From: Sbdesignservices [REDACTED]
Sent: 25 February 2019 00:02
To: Amber Willard
Subject: Re: aw/10/19/hh

I am the case officer on your application AW/10/19/HH at 31 Queens Fields West.

Proposed Elevations

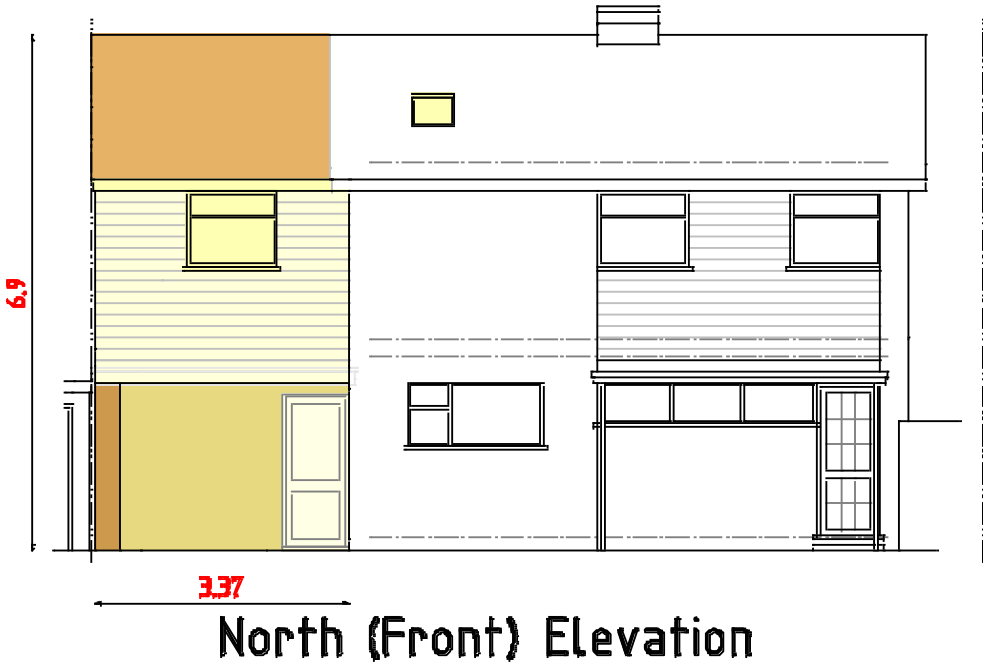
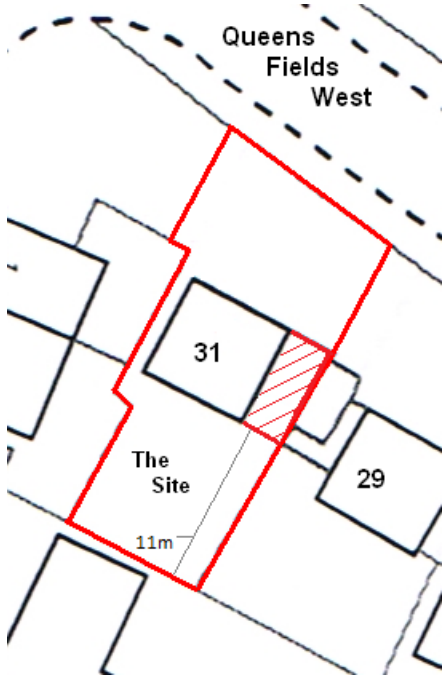
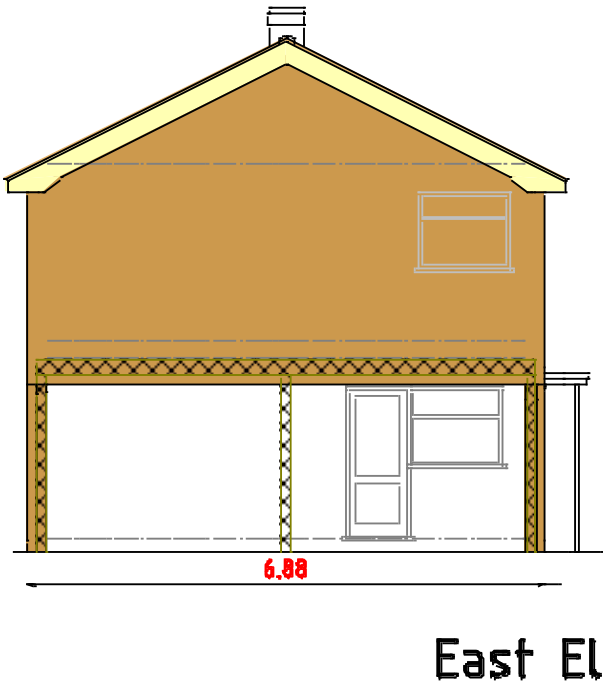
I am writing to enquire the colour of the proposed cladding to the front and rear elevation of the dwelling.

If this has not yet been decided a condition may need to be included in which details are submitted at a later date however in order to avoid this an email confirming what the proposed colour is will be sufficient.

Thank you for your email below. The property currently has white cladding to the front and rear and the new cladding will match this. It is not the intention of my client to change the colour.
